August 3, 2017

RE: **Small Cell ROW Use Permit Application(s)**
Reasons for Denial of ROW Use Permits 1701-153 (MIS12), 1701-158 (MIS17), 1701-130 (MIN05)

RE: **Small Cell ROW Use Permit Application(s)**
 Request for Additional Information – MIS01 through MIS24 and MIN01 through MIN15

NODE: MIN 12
ADDRESS: 4030 96TH AVE SE
CITY, STATE, ZIP: MERCER ISLAND, WA 98040
POLE ID: 221234-165980
EXISTING POLE HEIGHT: 30'-0"
PROPOSED POLE HEIGHT: 38'-6"

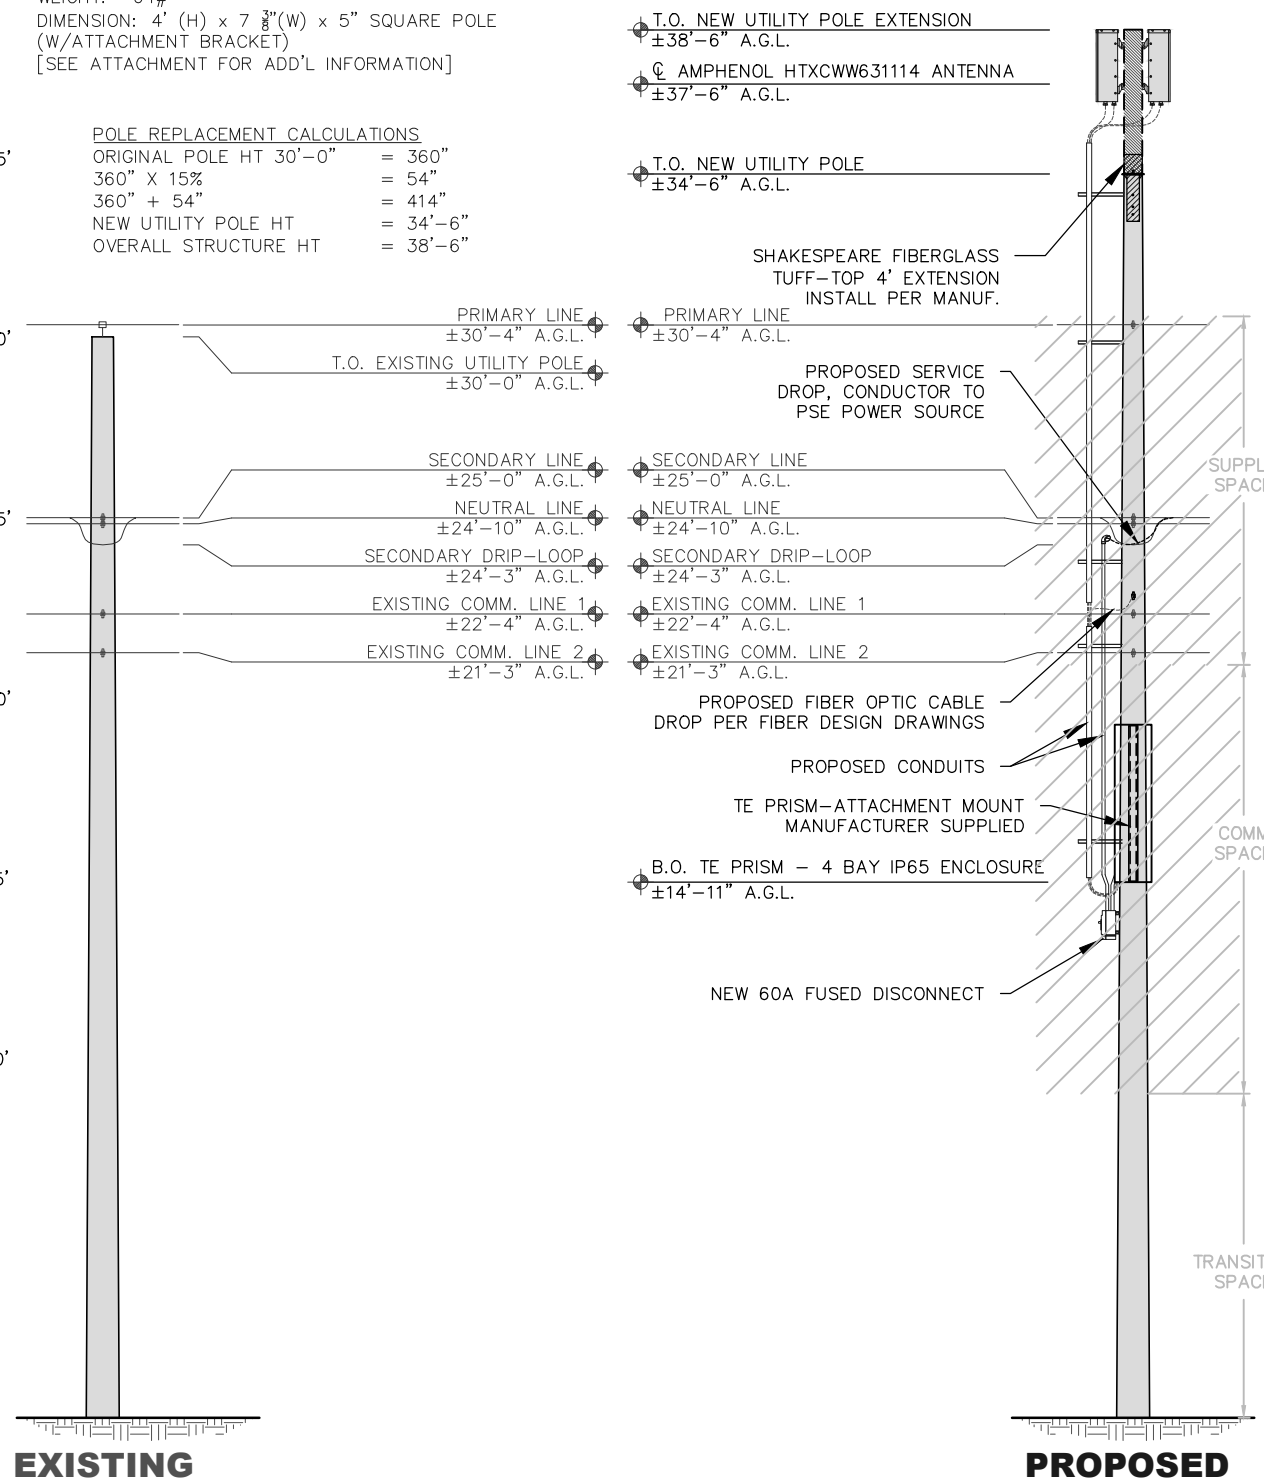
11. MIN12: Following a site visit, the City has concluded that the proposed facility may not minimize the appearance of small cell facilities from the adjacent residential structure to the maximum extent feasible; in particular it appears that the proposed small cell may impact the view of 4031 96th Ave SE as they are on a slope and the pole is in direct line with the house. Please evaluate alternate options for the location of the small cell facility.

22. Replacement pole with pole top mounting - MIN11, MIS01, MIS12, MIS24, MIN04, MIN06, MIN08, MIN12, MIN14, MIN15, MIS02, MIS03, MIS07, MIS08, MIS11, MIS12, MIS15, MIS16, MIS17, MIS21, MIS22

- a. It appears that a pole top mounting is proposed. This is not the preferred design method. Please provide documentation why the existing communication space on the PSE pole cannot be used. (Franchise agreement 6.4.3.1)

- c. Replacement poles are limited to a height increase of 15% of the original pole, or 10 feet taller, whichever is less. The proposed pole appears to exceed this limit. Please either provide documentation on how the additional height is necessary to close a significant gap or alternatively revise the proposed pole height. (Franchise agreement 6.4.5).

NODE INFORMATION	
NODE:	MIS02
ADDRESS:	8800 SE 78TH ST
CITY, STATE, ZIP:	MERCER ISLAND, WA 98040
POLE ID:	219793-165727
EXISTING POLE HEIGHT:	36'-10"
PROPOSED POLE HEIGHT:	46'-04"

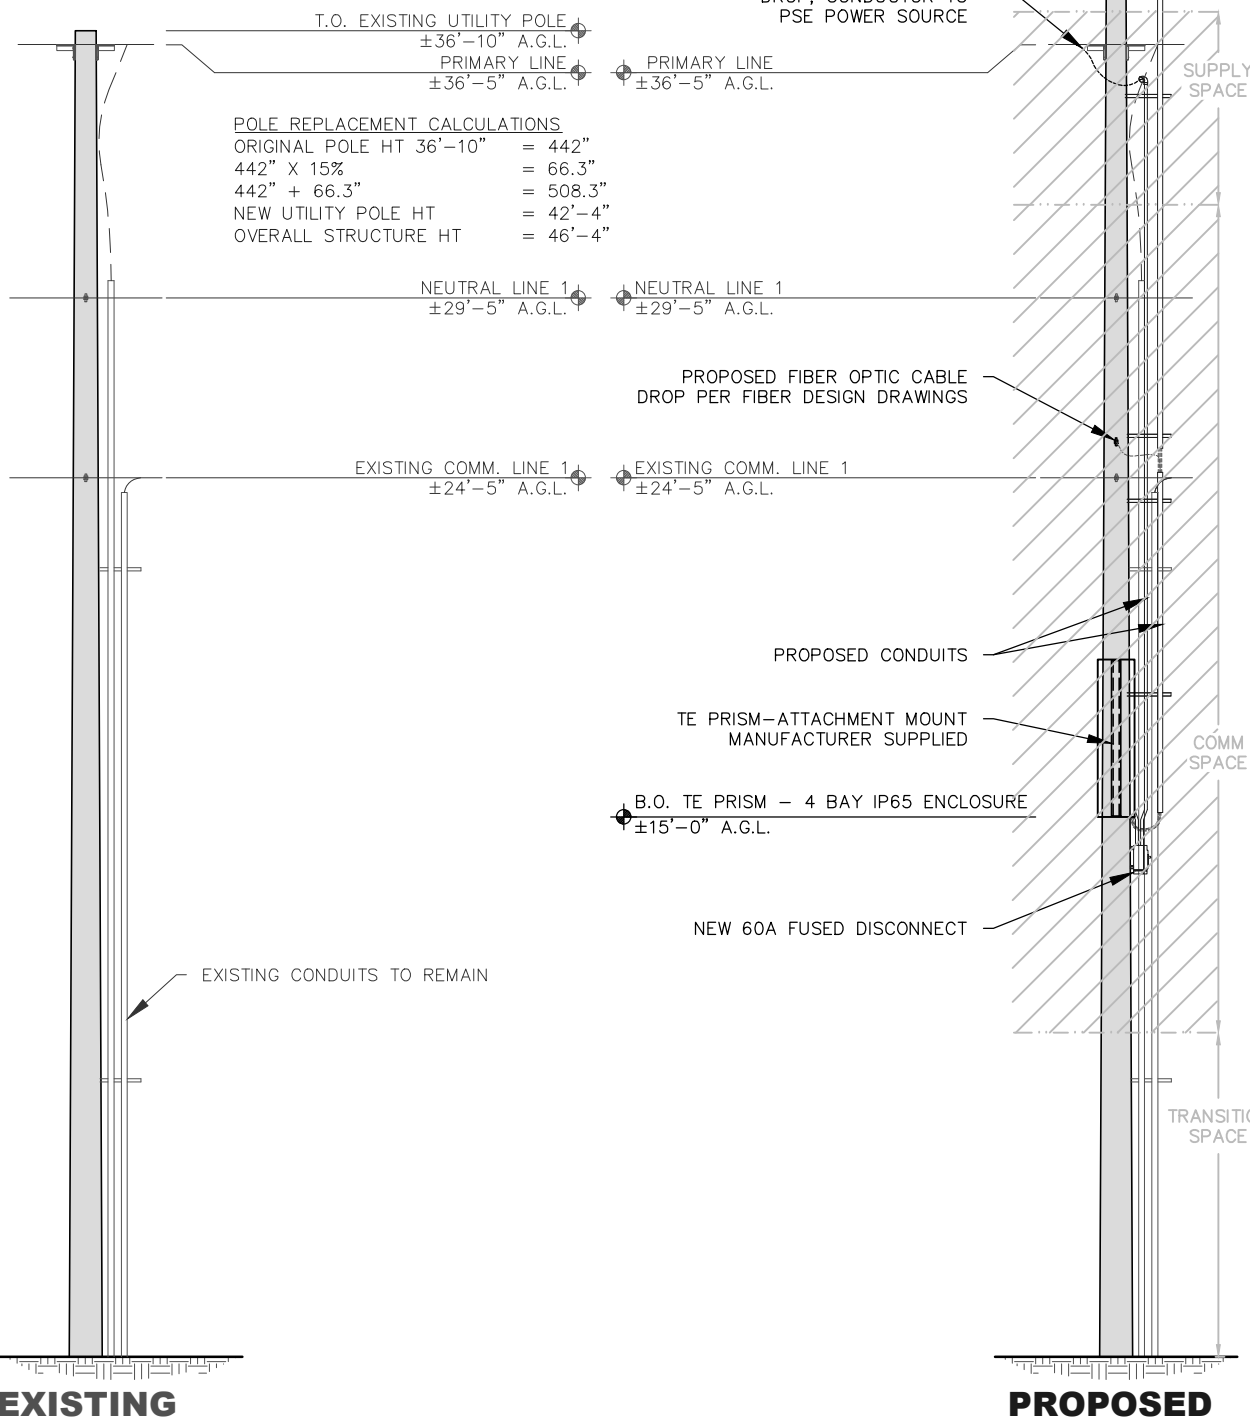
13. MIS02: Following a site visit, the City has concluded that the proposed facility may not minimize the appearance of small cell facilities from the adjacent residential structure to the maximum extent feasible; in particular, the proposed small cell appears to affect the view from a residential structure (presumed bedroom) at 8800 SE 78th St. Please evaluate alternate options for the location of the small cell facility.

## MIS12

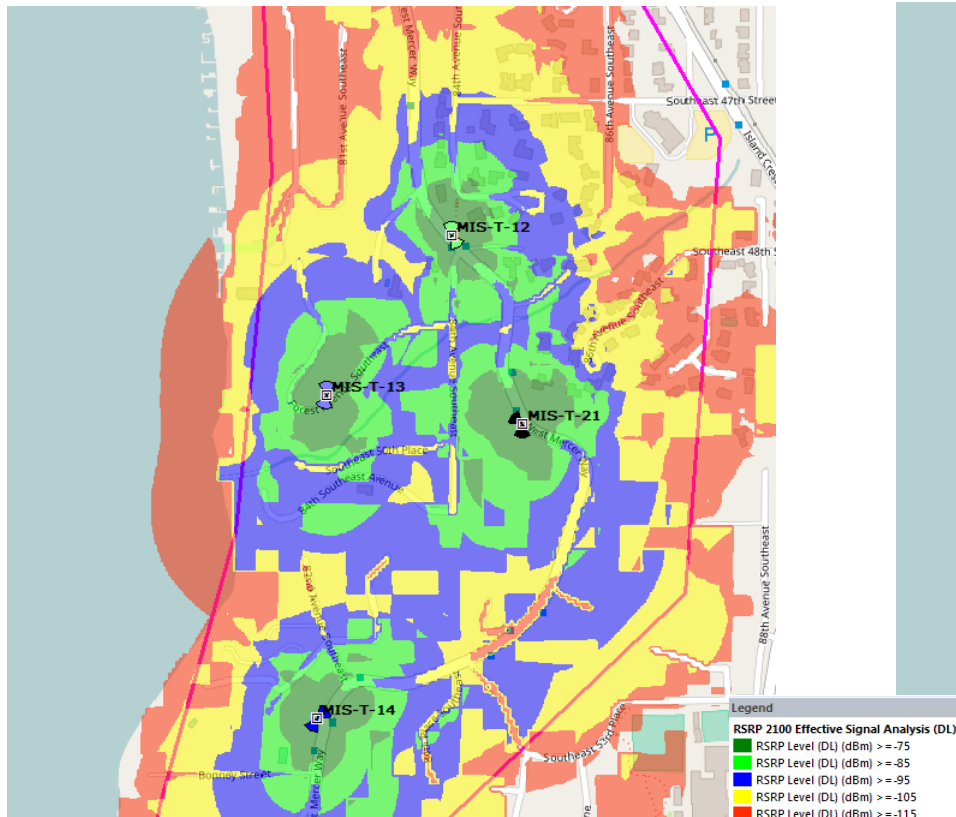
WA-CLEC, LLC failed to provide information addressing this item, in particular any analysis regarding expected impacts and coverage goals. Failure to provide requested documentation is also inconsistent with section 5.1 of the franchise agreement.

16. MIS12: Following a site visit, the City has concluded that the proposed facility may not minimize the appearance of small cell facilities from the adjacent residential structure to the maximum extent feasible. The proposed small cell facility may affect the view from 8400 SE 47th Pl. Please evaluate options for the location of the small cell facility.

NODE INFORMATION	
NODE:	MIS21
ADDRESS:	5033 W MERCER WAY
CITY, STATE, ZIP:	MERCER ISLAND, WA 98040
POLE ID:	220670-165644
EXISTING POLE HEIGHT:	33'-5"
PROPOSED POLE HEIGHT:	42'-5"

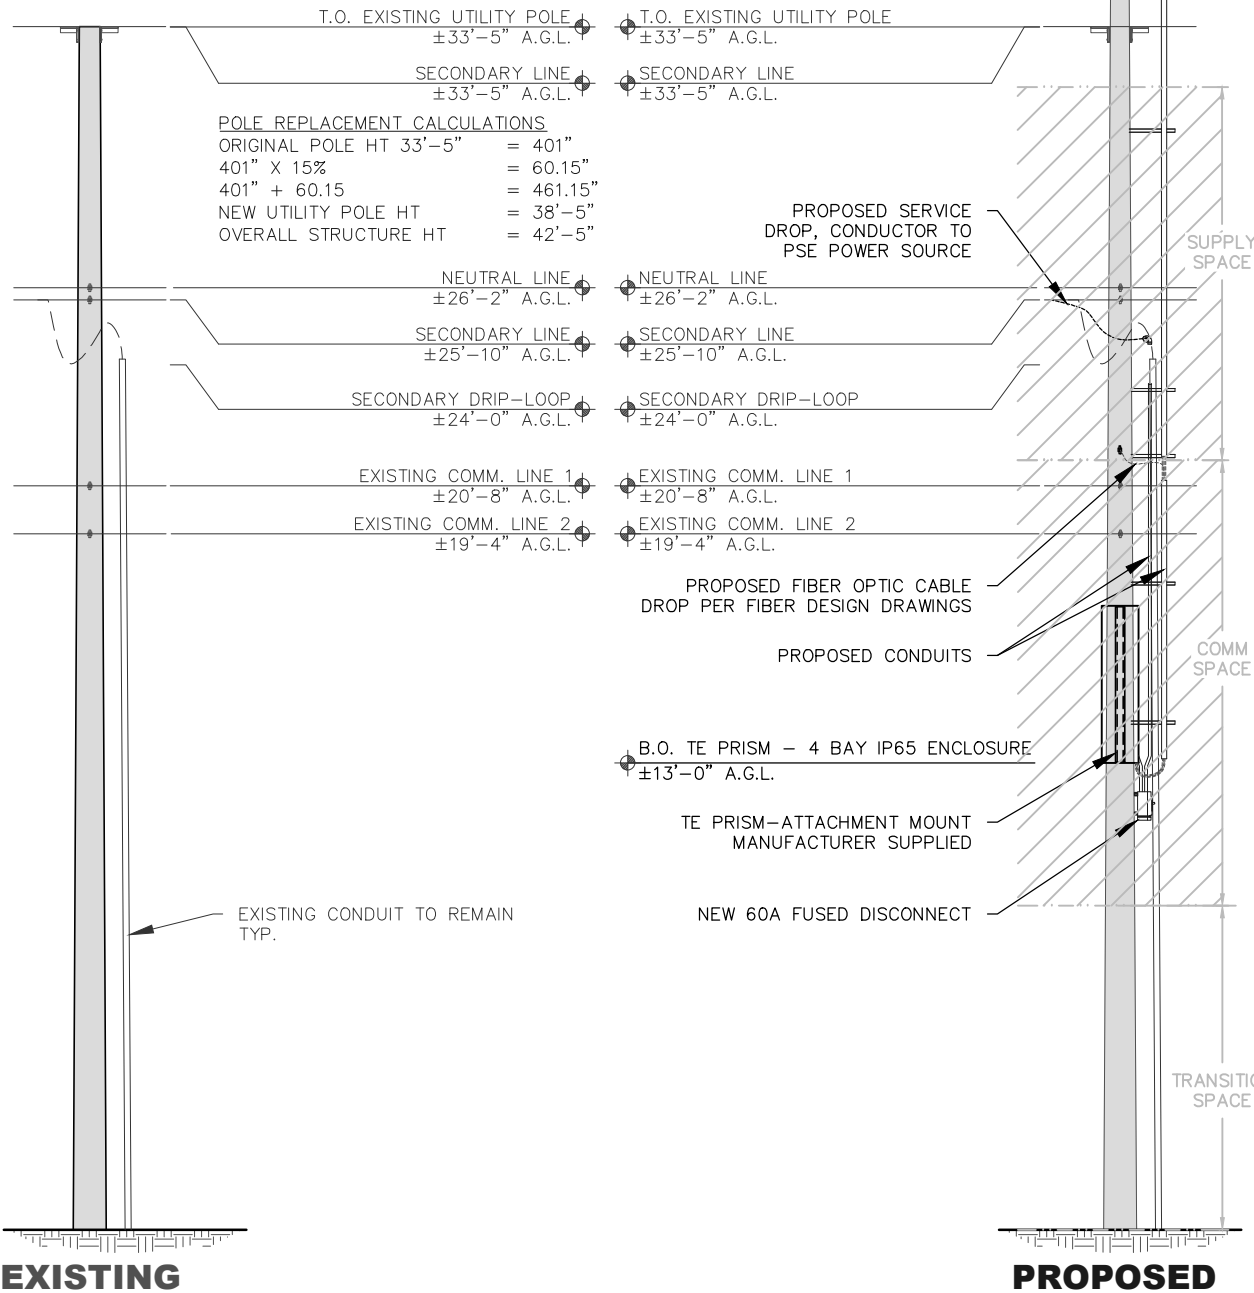
17. MIS21: Following a site visit, the City has concluded that the proposed facility may not minimize the appearance of small cell facilities from the adjacent residential structure to the maximum extent feasible. Per a request from the adjacent property owner residing at 5033 W Mercer Way and observation of staff, a better location for this facility may be the pole immediately north of the proposed site. Please evaluate options for the location of the small cell facility.

NODE INFORMATION	
NODE:	MIS23
ADDRESS:	7130 78TH AVE SE
CITY, STATE, ZIP:	MERCER ISLAND, WA 98040
POLE ID:	219980-165408
EXISTING POLE HEIGHT:	37'-0"
PROPOSED POLE HEIGHT:	42'-0"

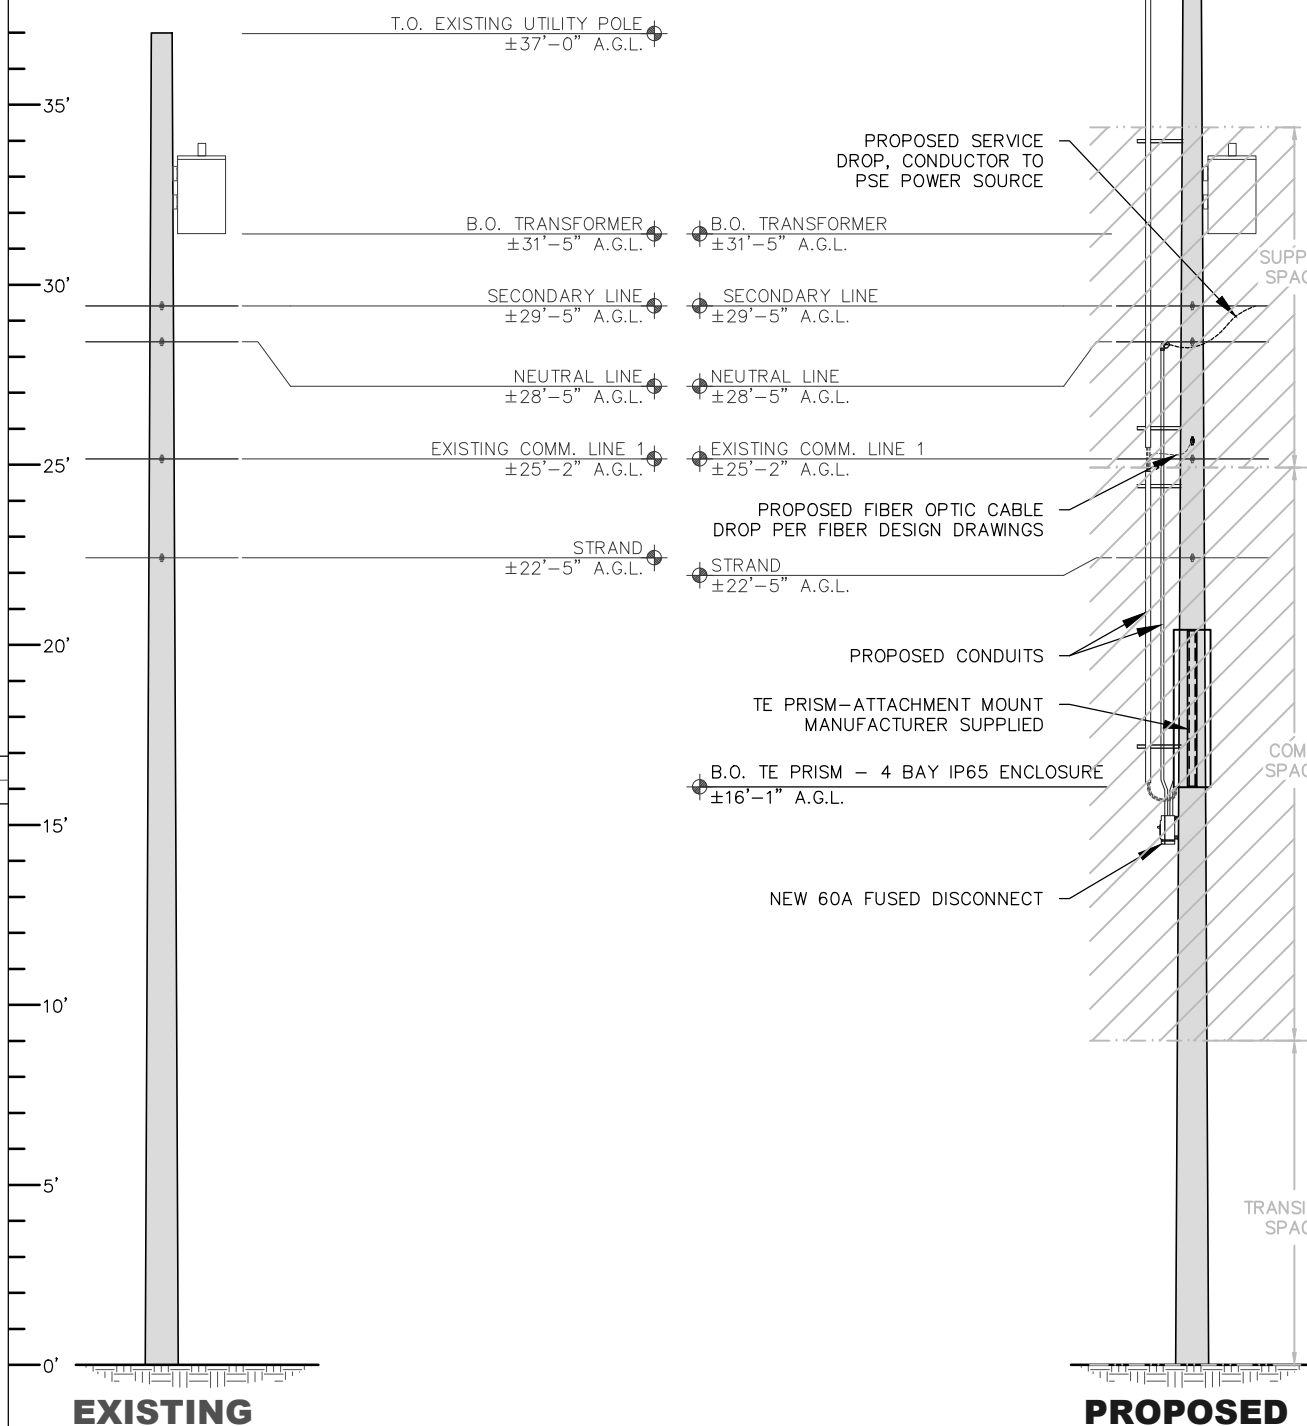
23. Replacement pole with pole top mounting – MIN03, MIS23
- a. It appears that a pole top mounting is proposed. This is not the preferred design method. Please provide documentation why the existing communication space on the PSE pole cannot be used. (Franchise agreement 6.4.3.1)

- b. If the antenna can be located in the communication space, please demonstrate that the proposed antenna is flush mounted (Franchise agreement 6.4.6.2)

- c. Please note that the equipment cabinet has to be located in the communication space, which is currently not reflected on the plans. (Franchise agreement 6.4.4).
